Appendix 1B: Limerick City & County Council (LCC) Consultation

Table B.1: Limerick City & Country Council (LCC) Consultations

Figure 2.5: XC201 Thomastown Proposed Route Alignment

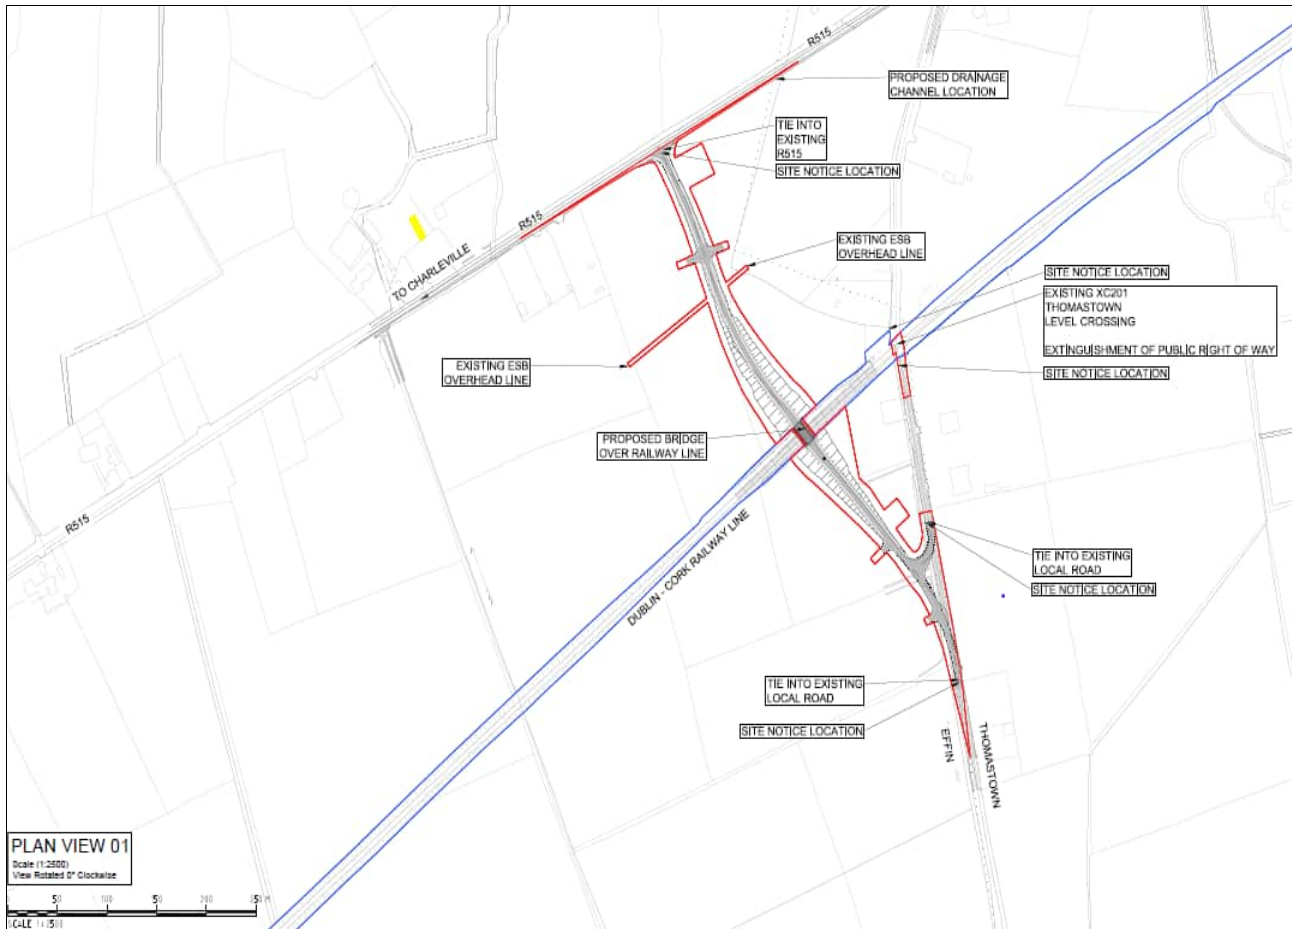
LCC requested that Jacobs project team attend the Cappamore-Kilmallock Municipal District Meeting.	Alex Bradley and Fiona McDonnell (Jacobs) and James Kenny (IÉ) attended meeting on 16 th January 2020 (see below notes).
Discussion regarding width of carriageway at XC201 Thomastown. 4m wide road cross section, with passing bays, to tie-in with existing carriageway cross sections was agreeable to LCC.	N/A
Discussion regarding roads to be extinguished at XC201 Thomastown. It was agreed in principal that sections of the existing road (particularly south of the existing crossing) which are being extinguished could be acquired by Iarnród Éireann, who could then dispose of the land accordingly.	Extinguished roads are to be broken up and landscaped where appropriate.
Thomas O'Neill (Heritage Officer) dated 10th January 2020. Comments were provided on the EIA Screening and Scoping Report, as follows: In section 5.5.1 Include Guidelines for Planning Authorities and An Bord Pleanála on carrying out Environmental Impact Assessment August 2018. Department of Housing Planning and Local Government (2018). This is for the sake of completeness as they are the most up to date planning guidance on the topic and unlike the 2017 EPA document are	<ol style="list-style-type: none"> 1) The Guidelines have been included for consideration and are highlighted at Volume 2, Chapter 4: EIA Process & Methodology. The Mid West Area Strategic Plan (MWASP) 2012-2030 and Objective IN06 of the Limerick County Development Plan is outlined within Volume 2, Chapter 5: Planning and the Planning Compliance Report that accompanies this Railway Order application.
